Demolition of existing detached garage & rear conservatory, enlargement of existing driveway, single storey side extensions, extension of existing roof over proposed extensions with 5 No. dormer windows.

17 Foamcourt Waye Ferring

Thank you for your internet representation made on 25th April 2018 which has been recorded as **'an objection'** with the comments as follows:

Title		PROPOSED FRONT AND REAR ELEVATIONS	
Scale	1:50 at A1	Dwg. No.	**C.C.P.P.** A B
Date	NOV 2017		
Drawn By	SP		
CAD_ref

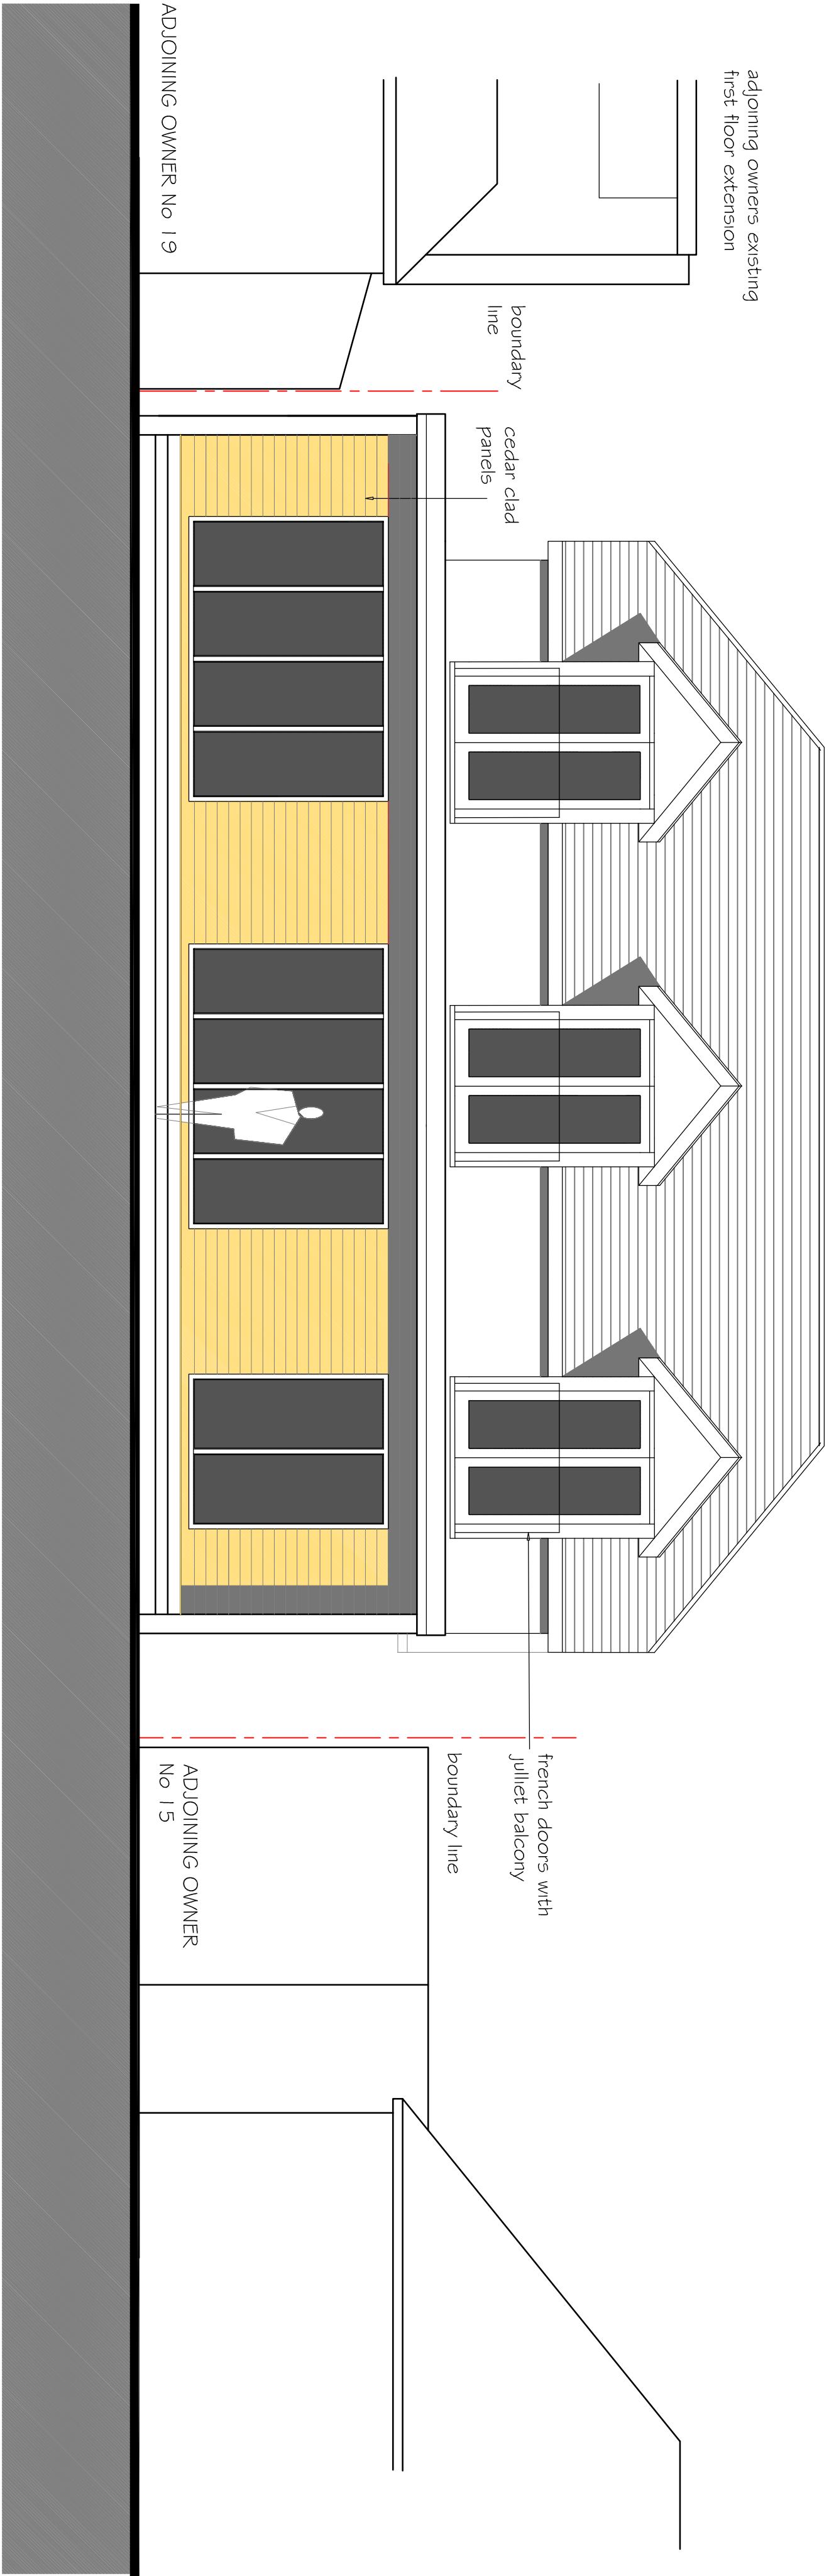
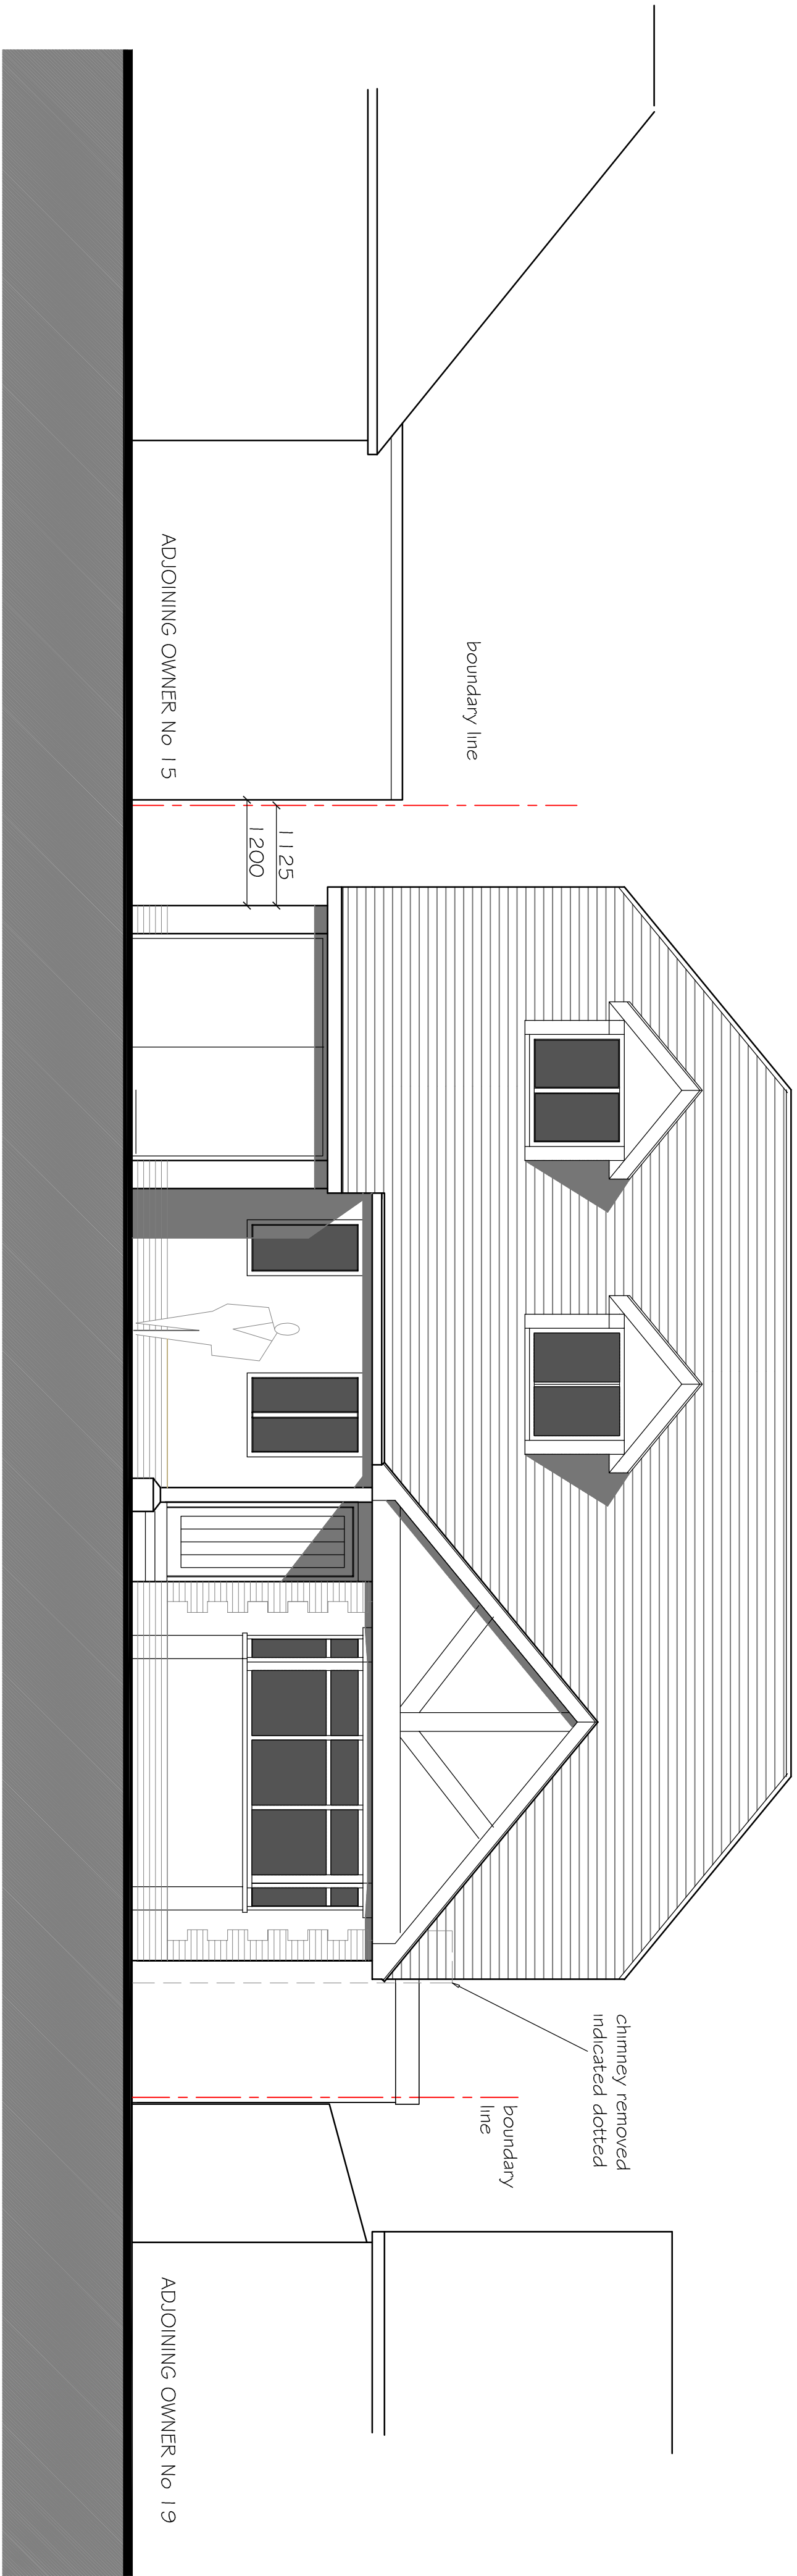
*I believe that this is an overdevelopment of the site.
A two storey building is out of character in a road of mainly bungalows.
This building will have an overbearing impact on my property.
The flat roof on the rear of the development used as a balcony will have a detrimental effect on my property. This balcony directly overlooks my rear garden with a resulting loss of privacy.*
